From: Mundy, Ben - Oxfordshire County Council <Ben.Mundy@Oxfordshire.gov.uk>
Sent: 05 August 2022 11:12
To: DC Support; Sarah Greenall
Cc: Transport CDC Minor; Cllr George Reynolds
Subject: 22/01942/F New Rectory, Acre Ditch, Sibford Gower, OX15 5RW

Planning Application: 22/01942/F

Location: New Rectory, Acre Ditch, Sibford Gower, OX15 5RW

DRAWING:
Plans and Elevations

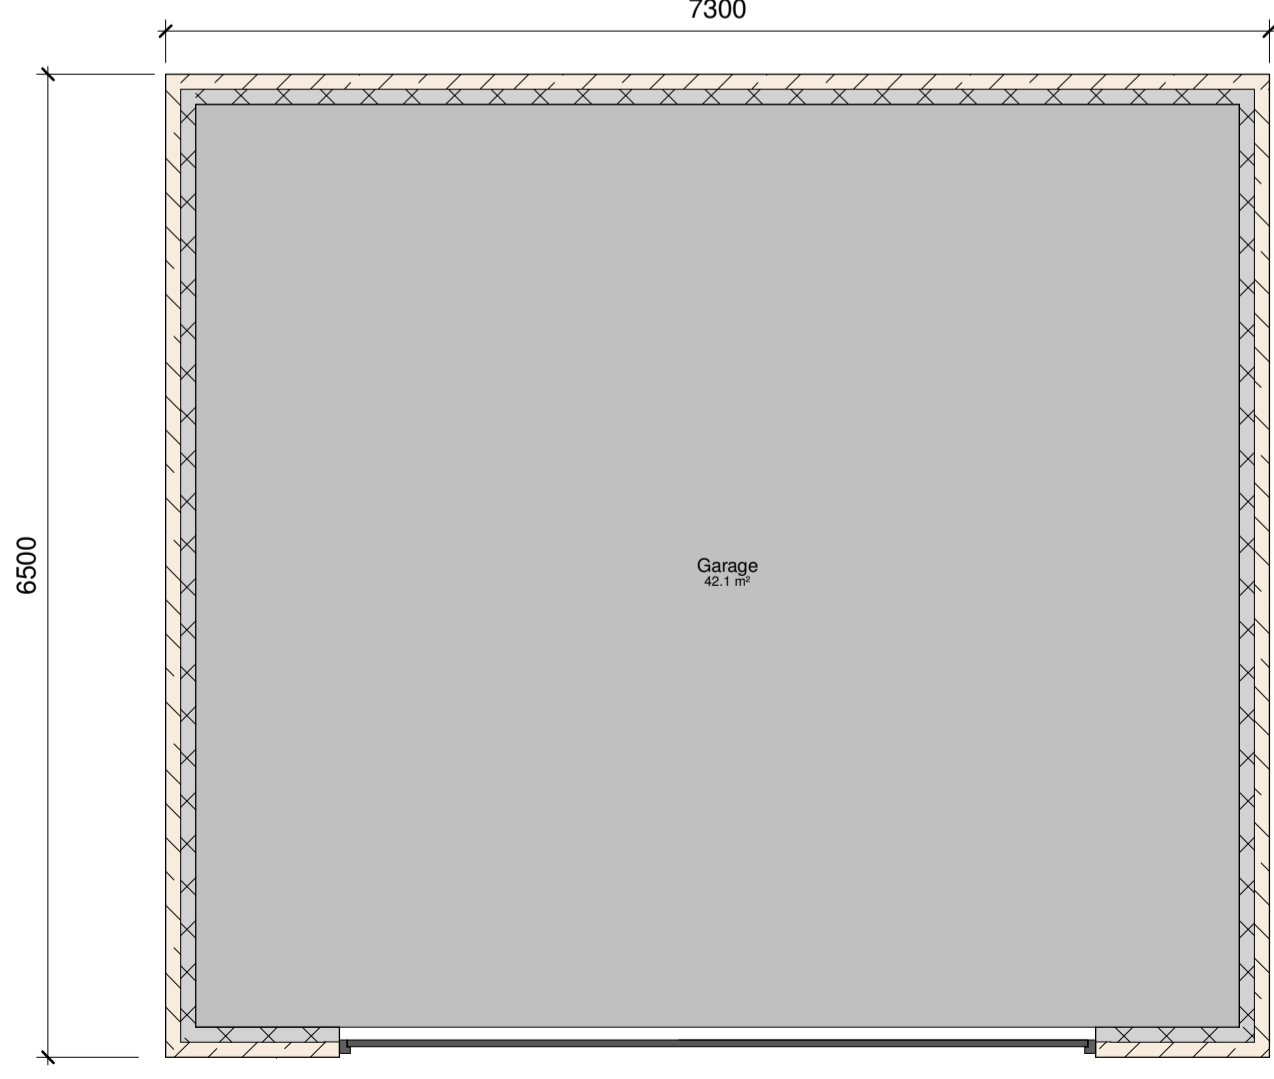
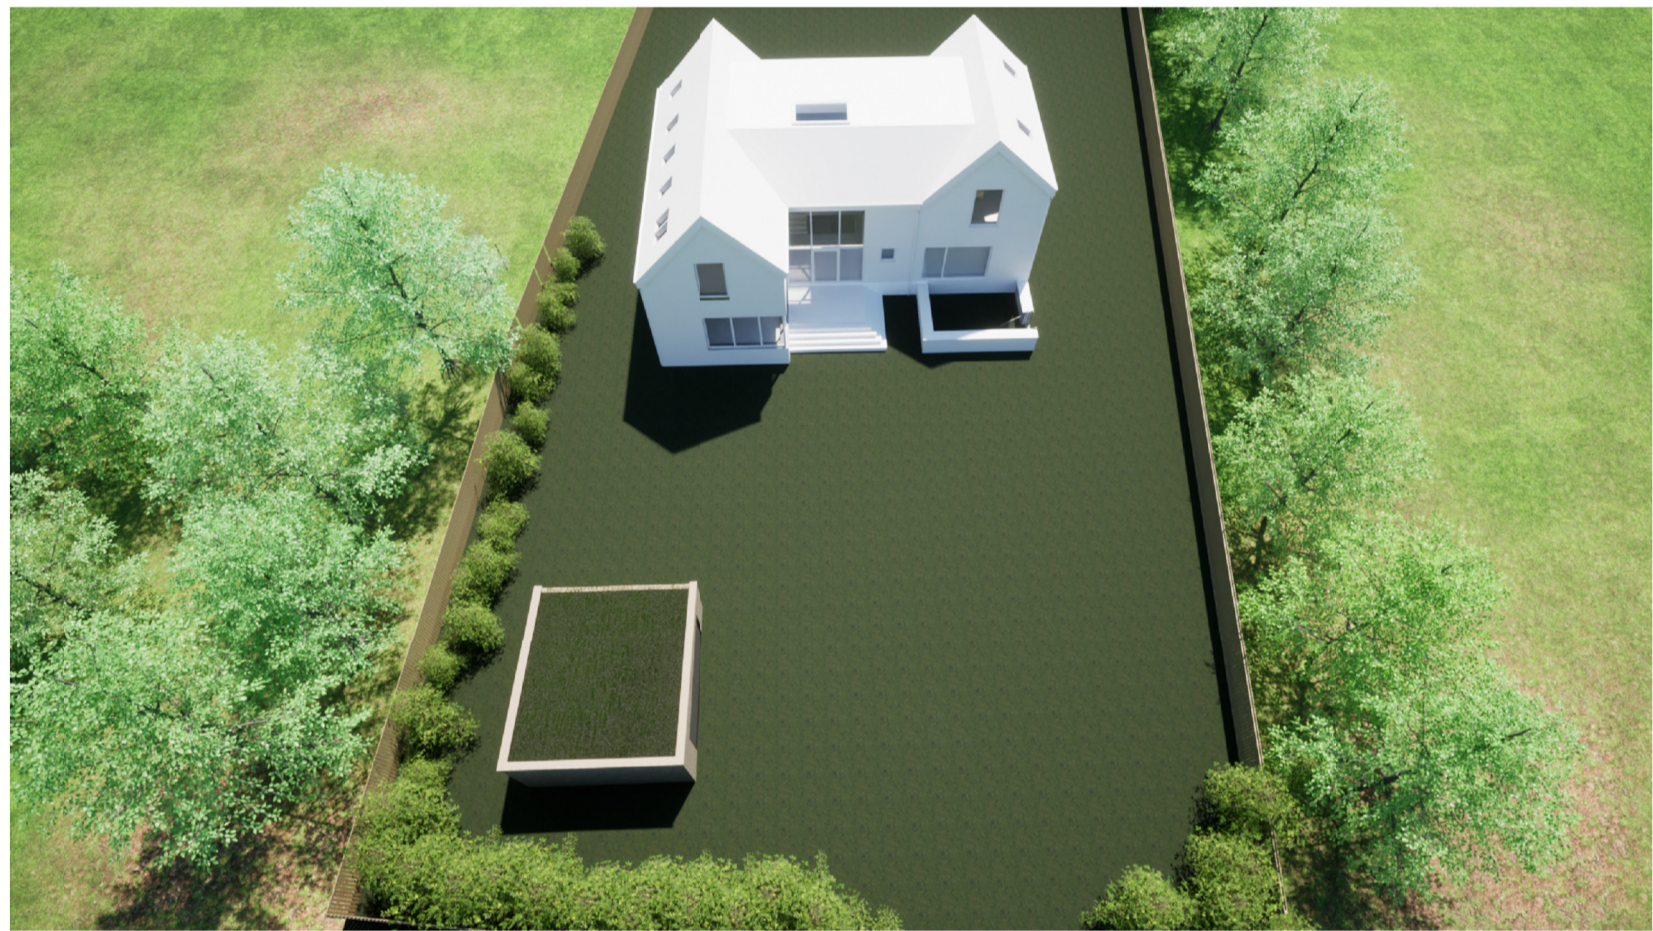
The proposed garage appears to be allocated parking for the proposed development within this site. The garage is within the correct dimensions to accommodate for two vehicles (6m x 6m) and the number of spaces conforms to the OCC Maximum parking standards. The dimensions of the garage mean it can also be used for cycle parking. This application proposes no changes in access from the existing arrangements.
